Forest Lakes Filing No. 5
Transportation Memorandum
(LSC #194530)
August 30, 2019

RE: Forest Lakes Filing No. 5
El Paso County, Colorado
Transportation Memorandum
LSC #194530

OVERALL SITE EXHIBIT

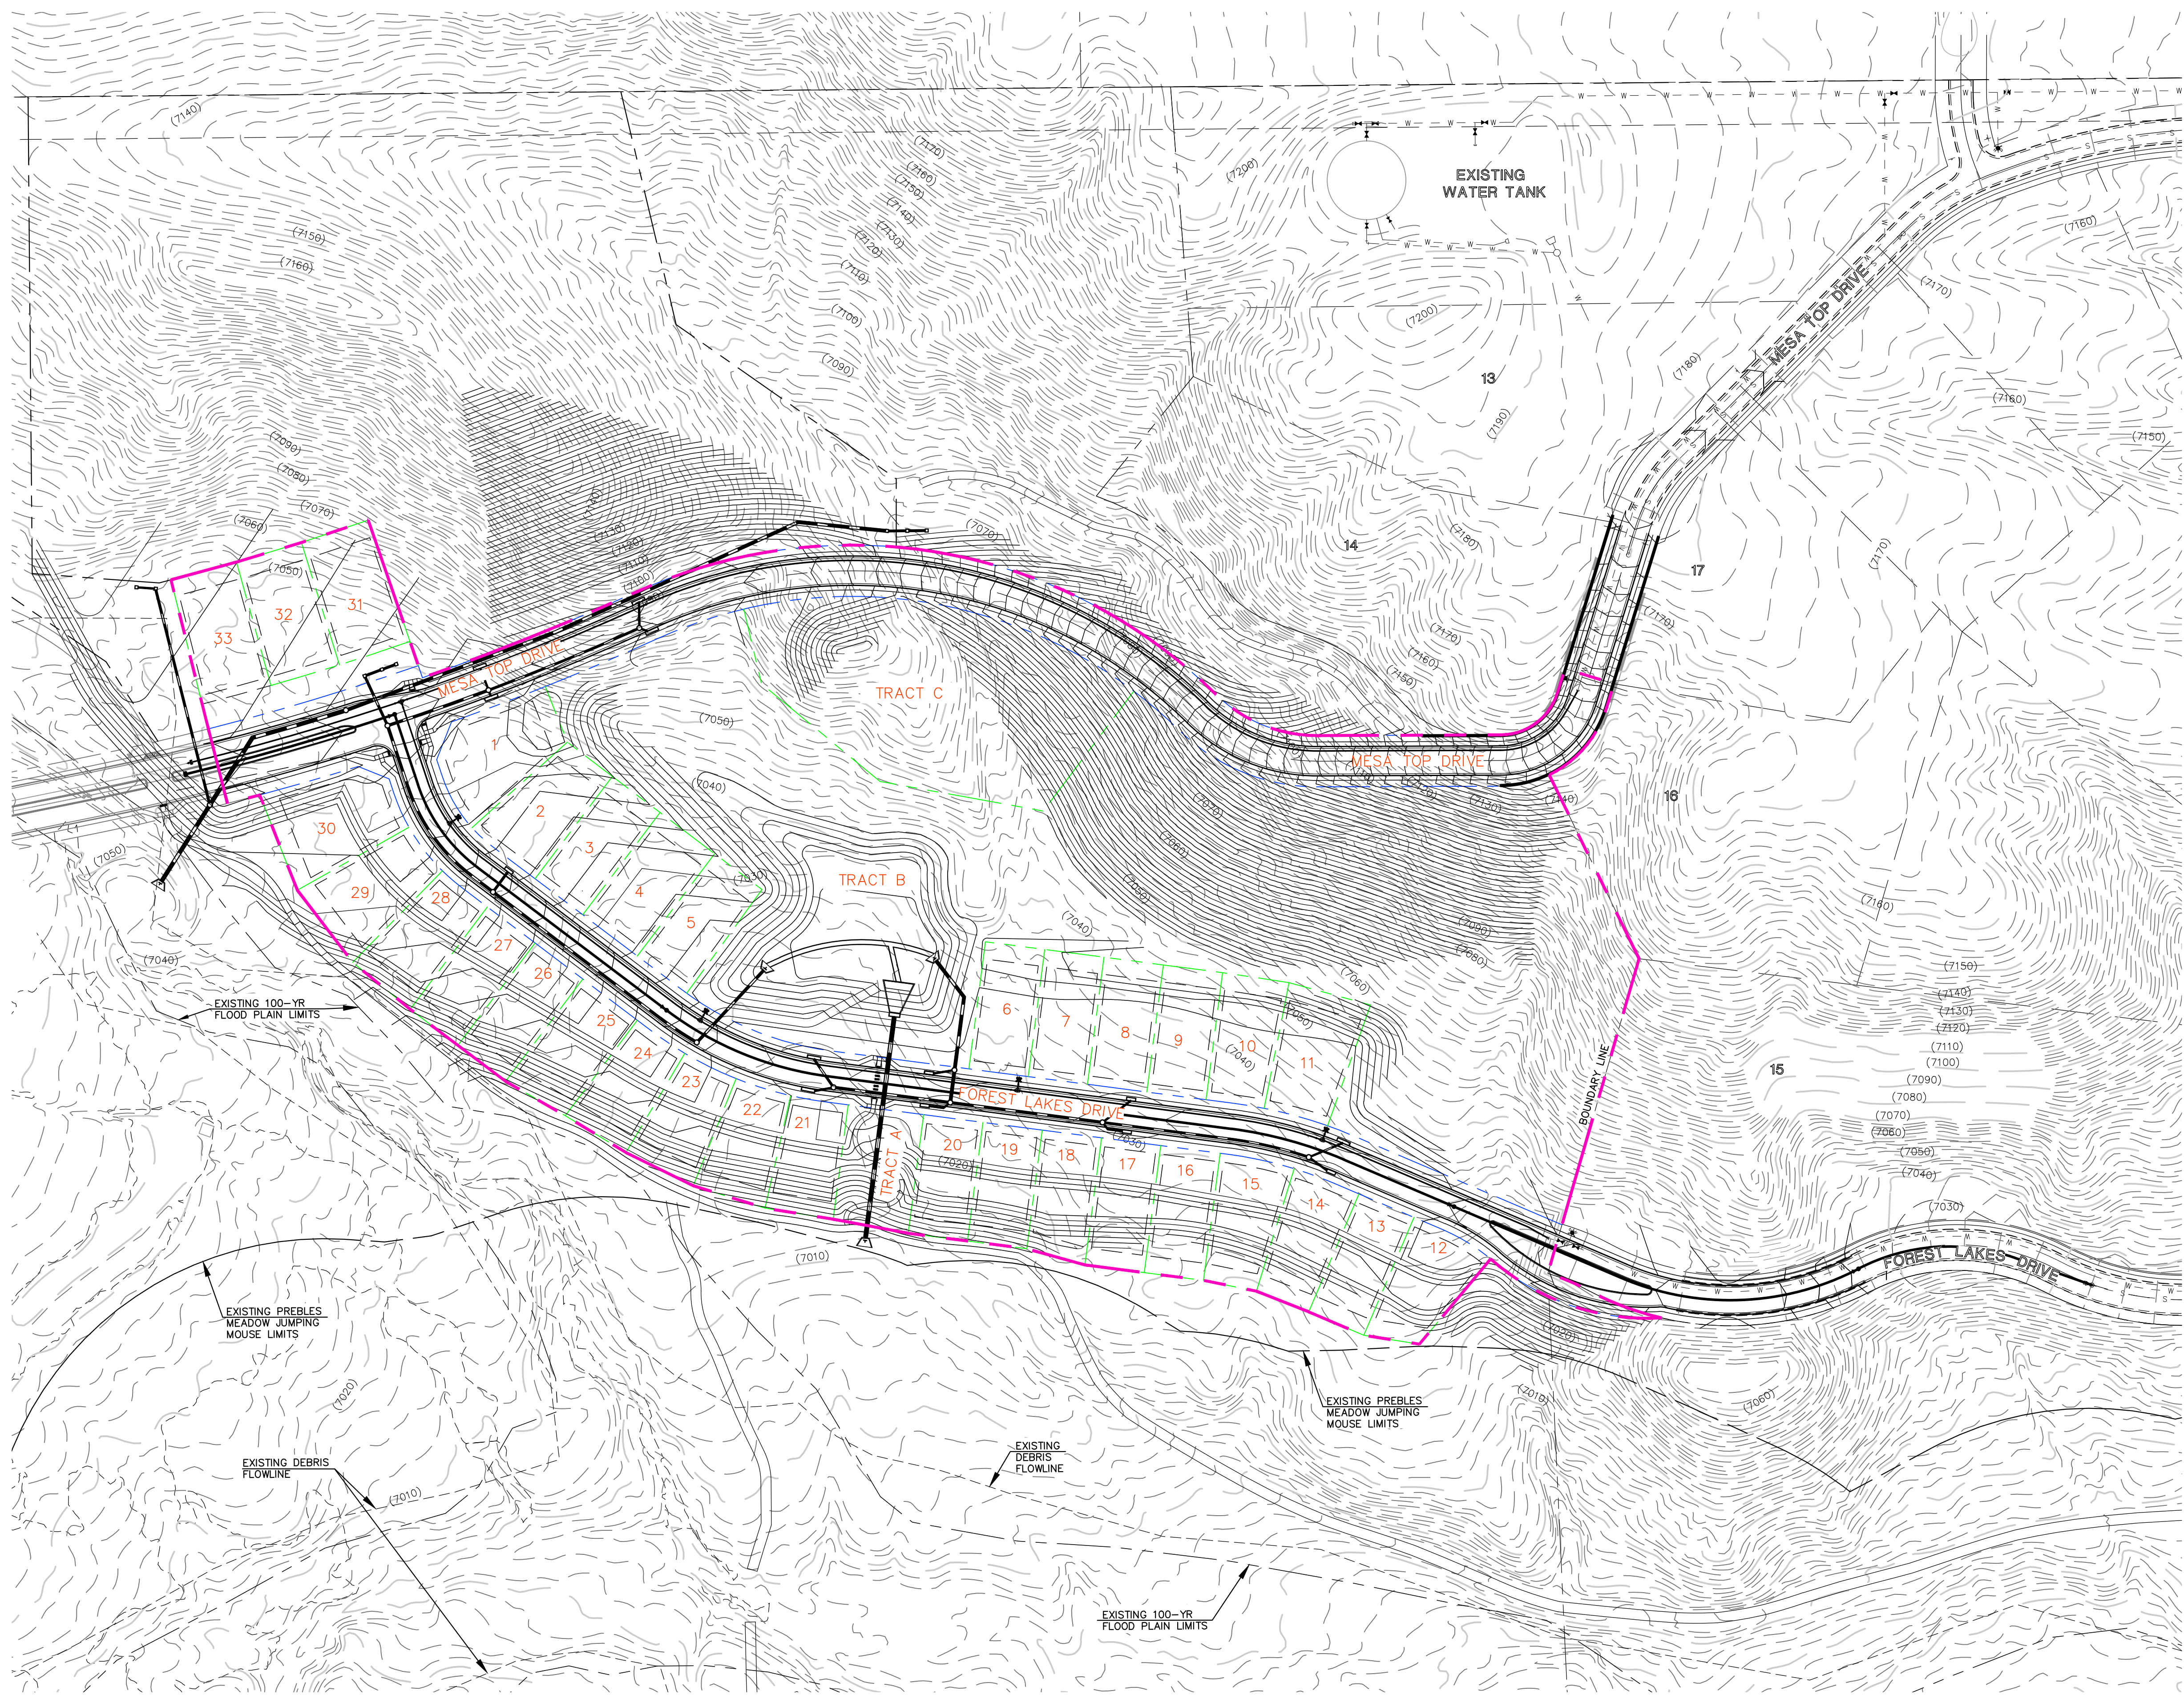
Table 1 and the Overall Site Exhibit are missing.
Include with the resubmittal.
